M60/M62/M66 Simister Island Interchange

TR010064

7.18 Statement of Common Ground with Bury Council

Version	Date	Status of Version
P02	10 January 2025	Examination Deadline 5

FIGURE 5.11

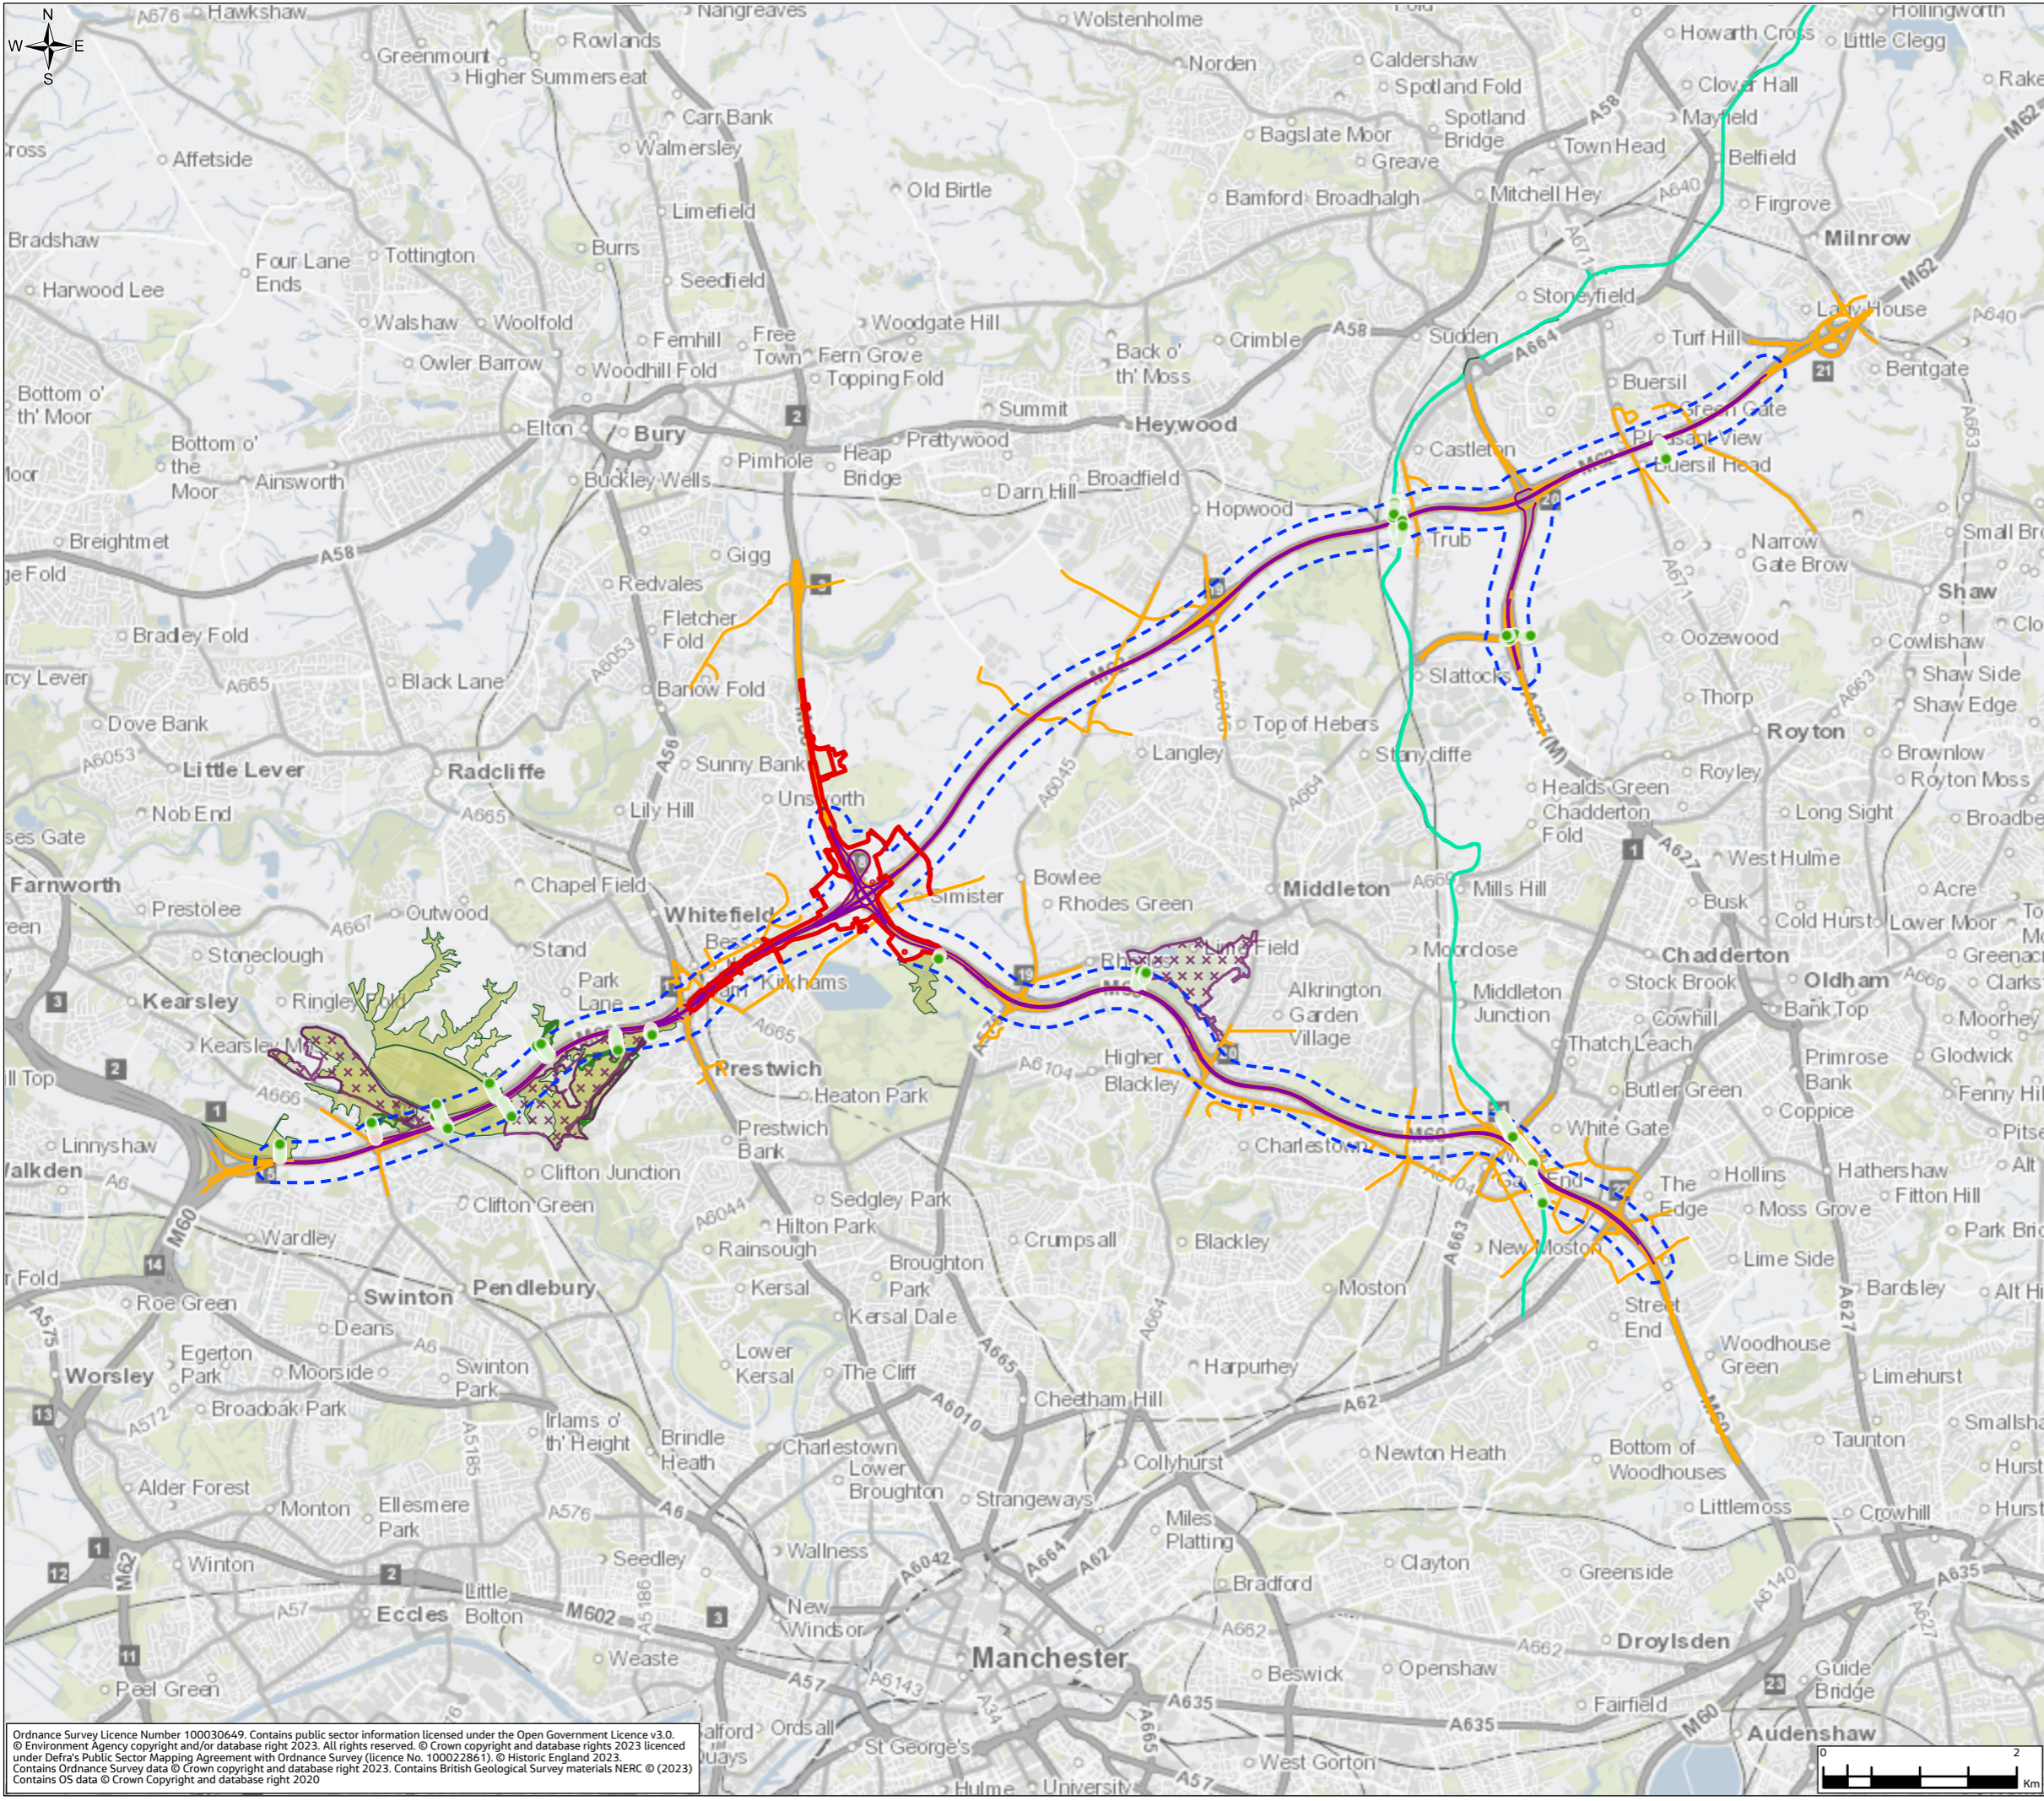
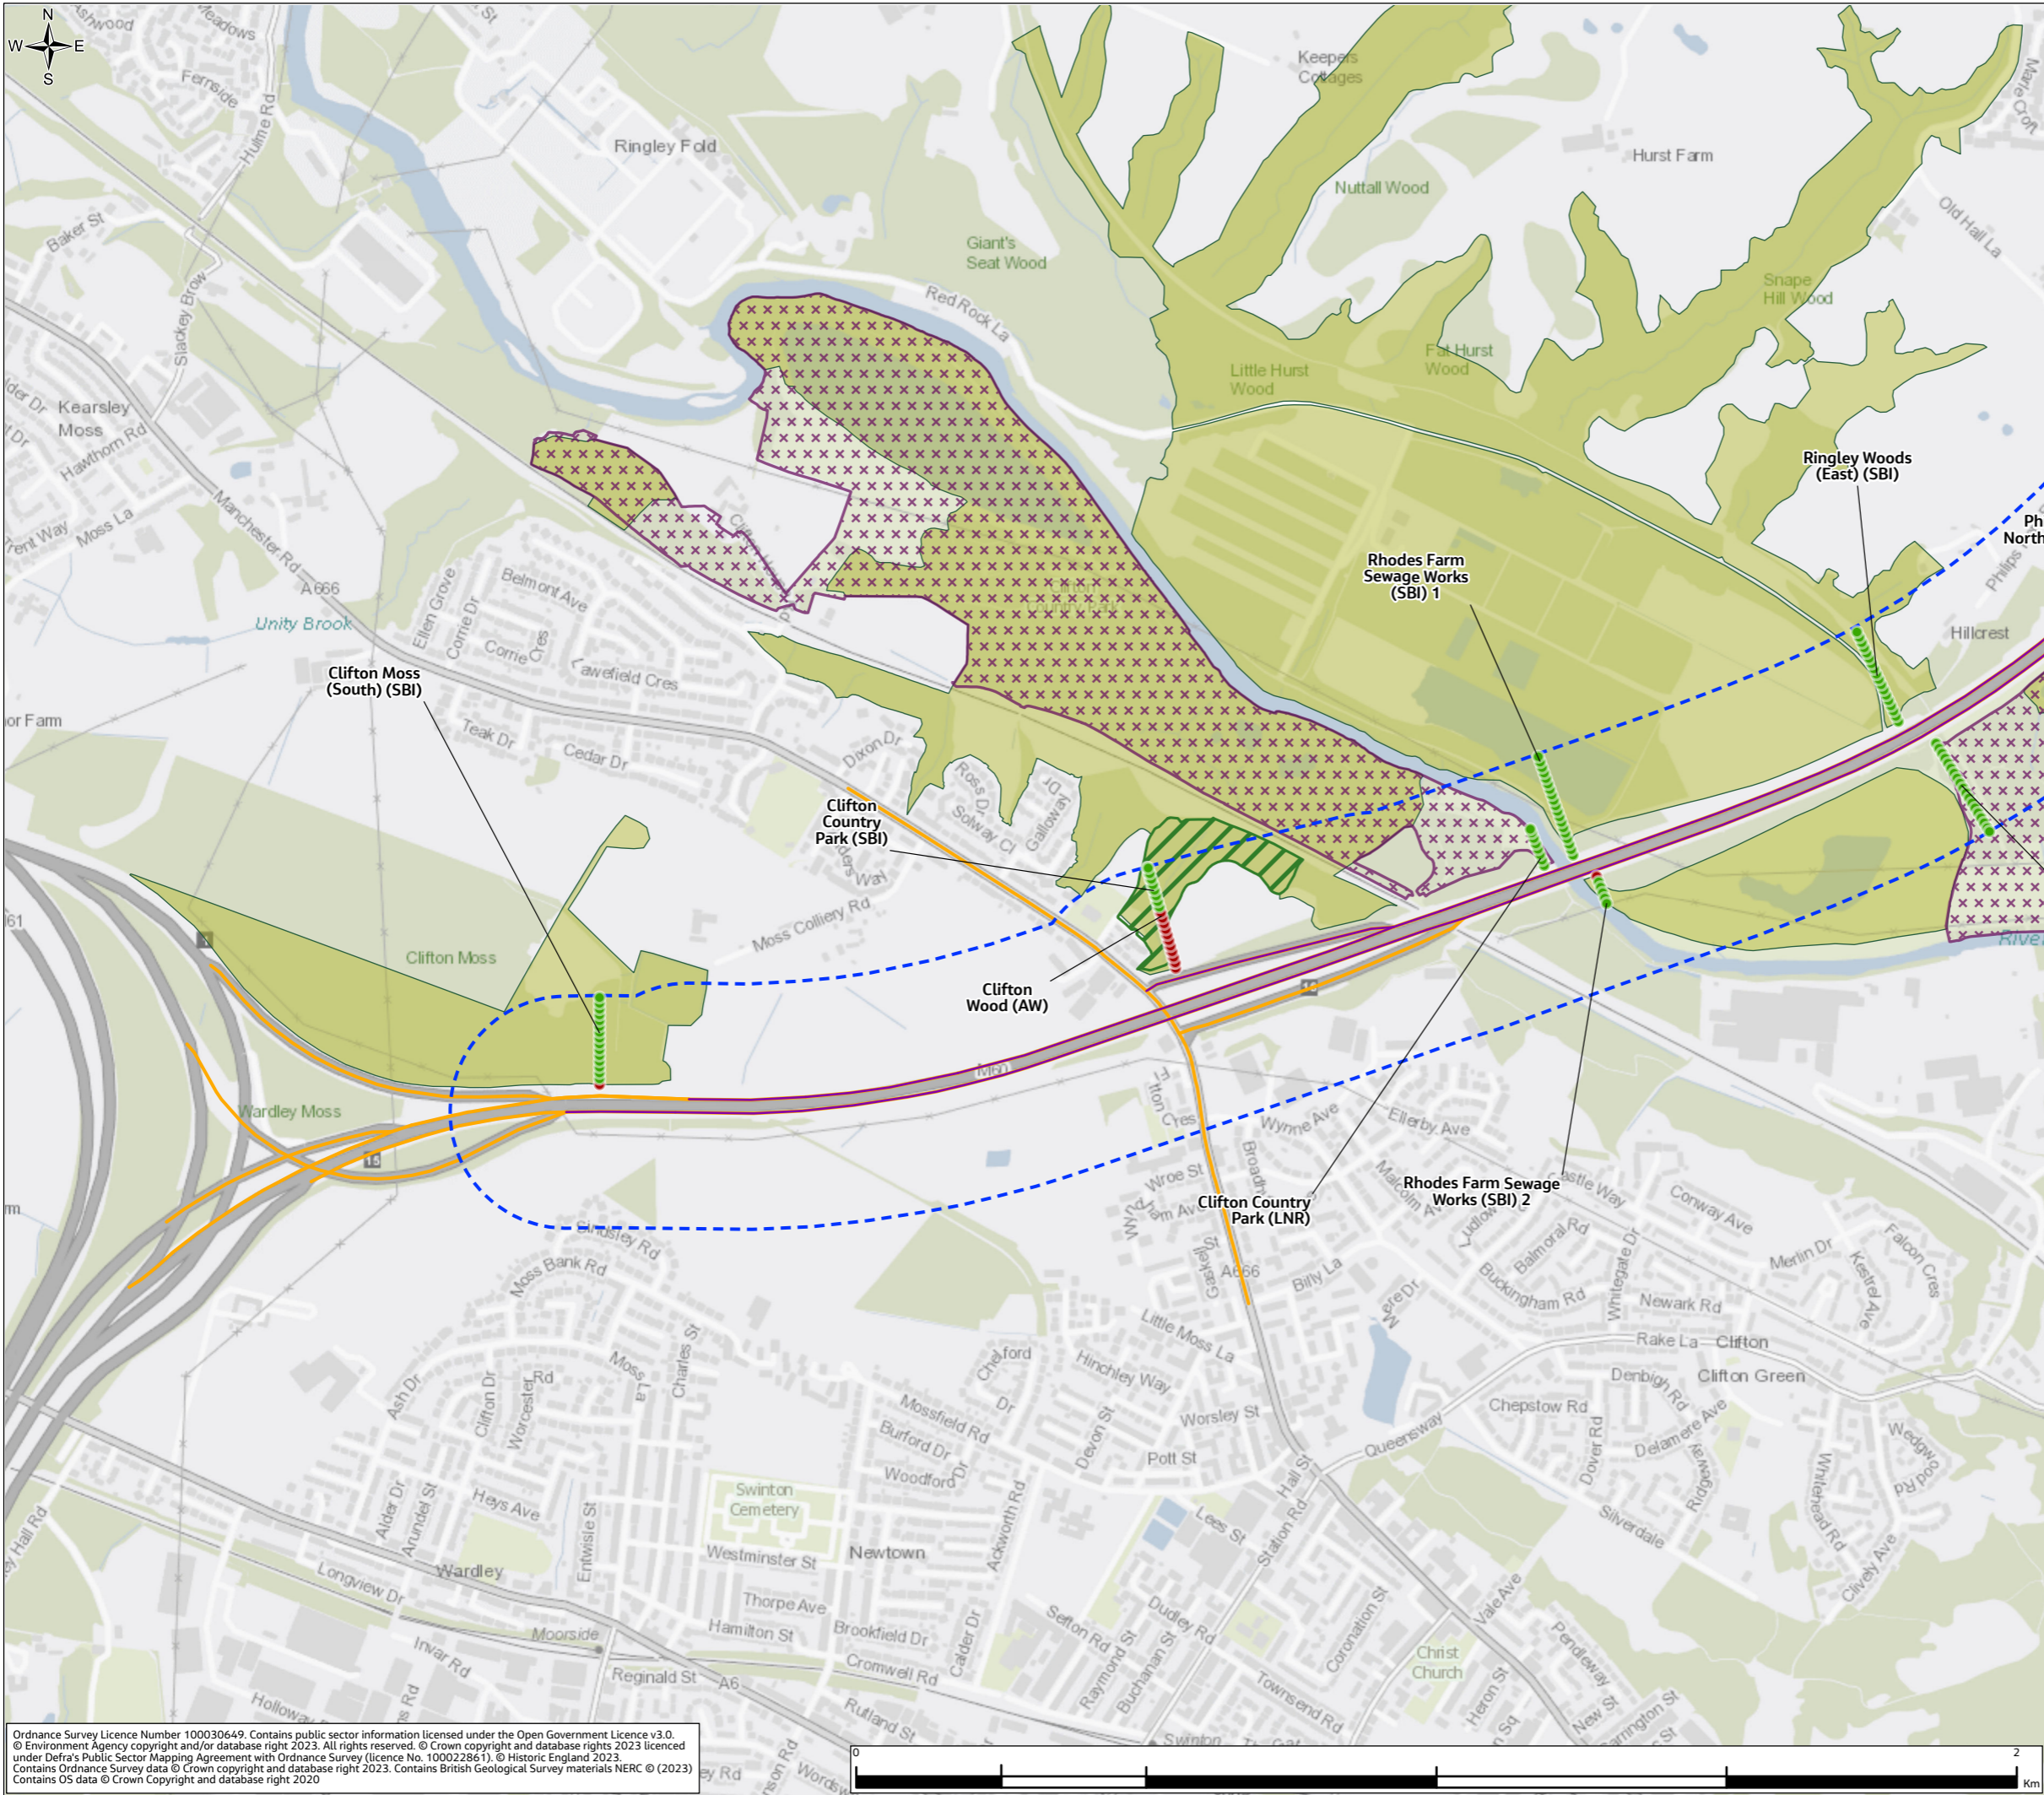
Ref	Issue	Doc Ref	Bury Metropolitan Borough Council Position	National Highways' Position	Agreement Likely	Status	Date
5	The acceptability of the ecological impact assessment - construction and operational phases	<p>Chapter 8: Biodiversity of the Environmental Statement [REP1-025]</p> <p>Appendix 5.2: Air Quality Results [APP-080] of the Environmental Statement Appendices</p> <p>Figure 5.9: Construction Ecological Assessment Results of the Chapter 5: Air Quality (Figures 5.8-5.9) [APP-060]</p> <p>Figure 5.11: Operational Ecological Assessment Results Chapter 5: Air Quality (Figures 5.10-5.11) [APP-061]</p>	<p>Following review of the specified documents, Bury Metropolitan Borough Council notes that's based on the information provided, the findings and conclusions of the ecological risk assessment appear reasonable.</p> <p>Bury Metropolitan Borough Council notes that at the stage of Scheme's Statutory Consultation , it was understood that Natural England has previously commented upon the potential impact on ecological receptors from air pollution.</p> <p>Following review of Natural England's relevant representation [RR-009] submitted to the Examining Authority on the 24 June 2024, Bury Metropolitan Borough Council is satisfied that the Scheme will have no adverse effects on the Rochdale Canal Special Area of Conservation from air pollution. Bury Metropolitan Borough Council has no further comments.</p>	<p>The Applicant notes Bury Metropolitan Borough Council's comments on the findings and conclusions of the ecological assessment.</p> <p>The Applicant notes that in Table 3.1 of the Statement of Common Ground with Natural England [REP1-017] Natural England confirmed that they are satisfied that the Scheme will have no adverse effects on Rochdale Canal SAC.</p>	Yes	Agreed	28/08/24
